City of Ryde Submission

Modification 1 Wicks Road Construction Support Site SSI-8863-Mod-1

(Modification to include 160 Wicks Road as support site

Submission Date: 22 November 2022

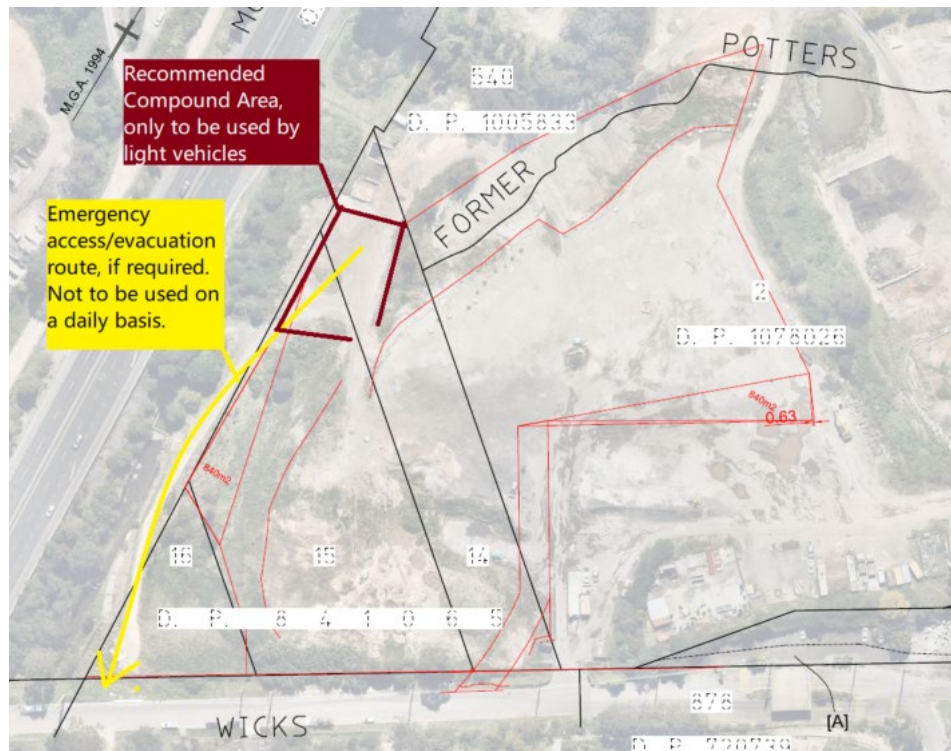
- Culvert under the site: Site usage plan is to show the exact position of the culvert including any inlet structures. With reference to the figure below, the secondary route marked yellow passes over the old culvert at its shallowest points, therefore, the use of this route must be limited to emergency use only, such as site evacuation. It should not be used on a daily basis by heavy vehicles. A pre and post construction dilapidation report on portions of the Mainline culvert lying beneath the lease area, including both CCTV images and video, will be required to be submitted to Council. Any damage is to be repaired. A Noise & Vibration

Plan is to include measures to protect the integrity of the culvert. The area outlined brown below is an area where stockpiling should be avoided. Other uses of the area marked brown, such as a site compound or light vehicle parking, is suggested.
